The Member Secretary,
Chennai Metropolitan
Development Authority,
No.1, Gandhi Irwin Road,
CHENNAI -600 008.

B3/21174/2004

Area Plans Unit - Planning Permission
- Proposed construction of Ground Floor +
2Floors + 3Floors part Residential building with
10 dwelling units at New Door No.69, Siruvallur
Main Road, Old S.No.12,13,18/6part, T.S.No.18
and Block No.14 of Siruvallur Division,
Chennai - Remittance of Development Charge
& Other Charges - Requested - Regarding.

SECTION ON (Y-Y)

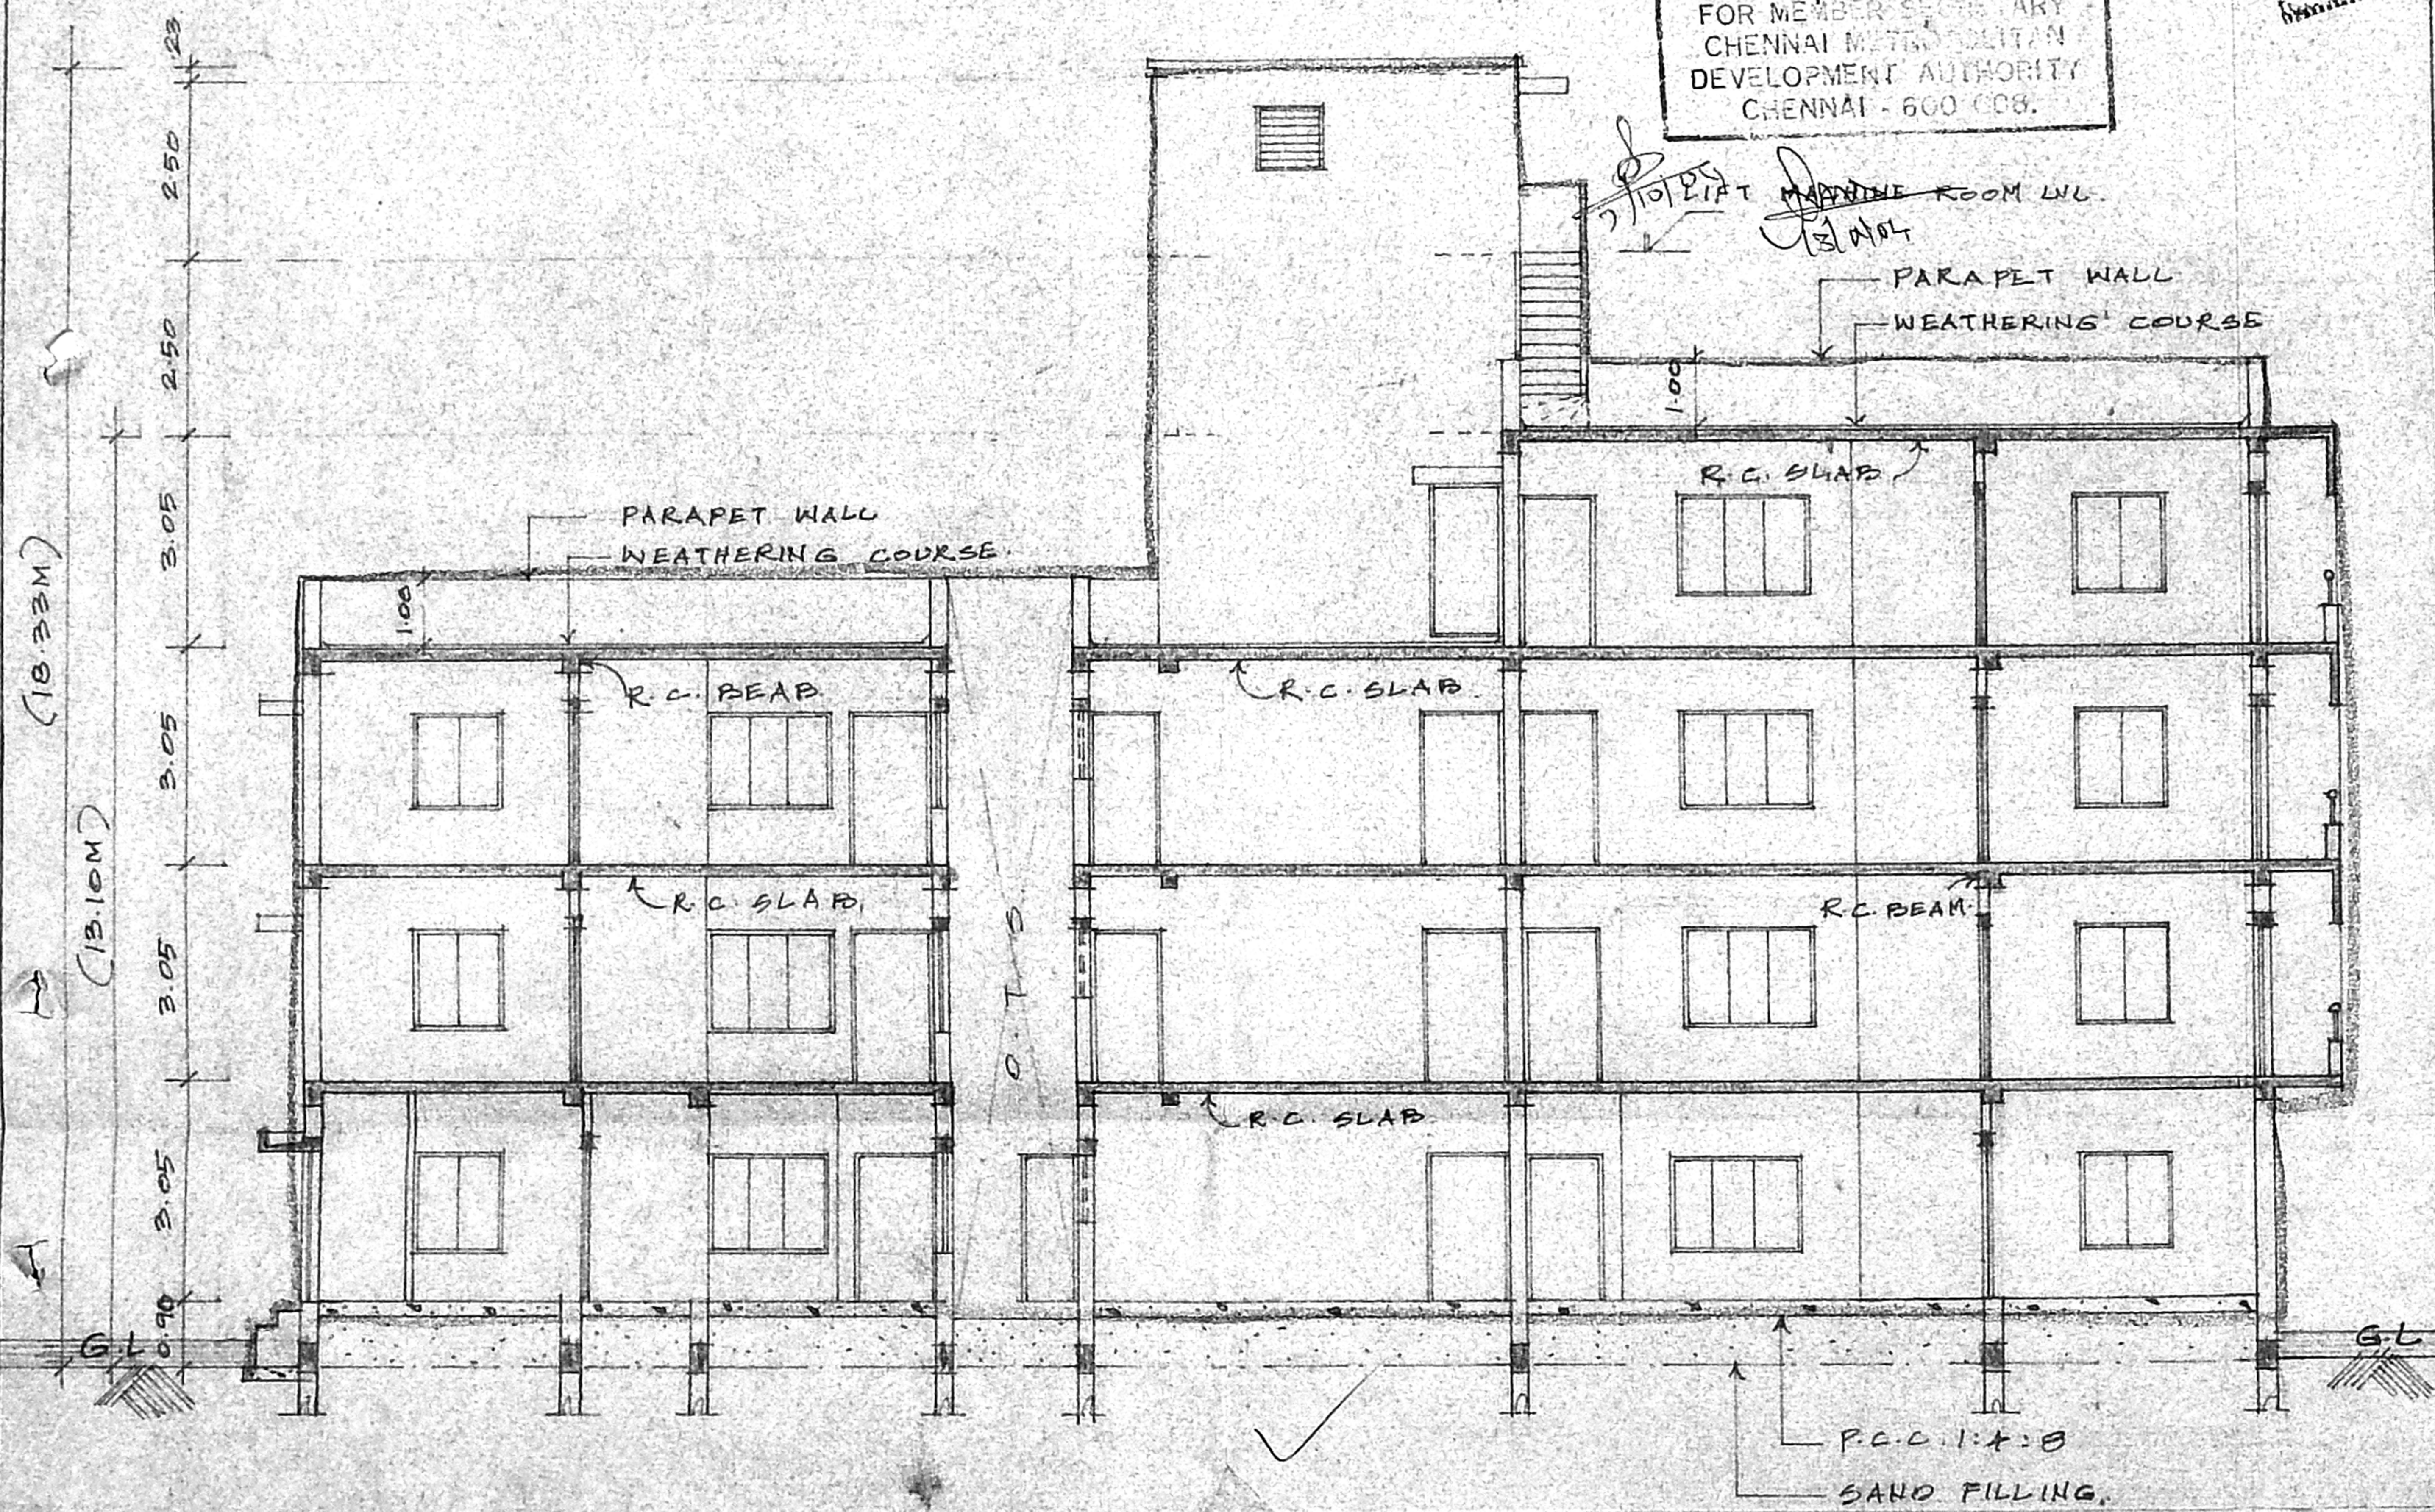
- b) **Five copies of revised plans with longitudinal sectional plan showing the low terrace in third floor.**
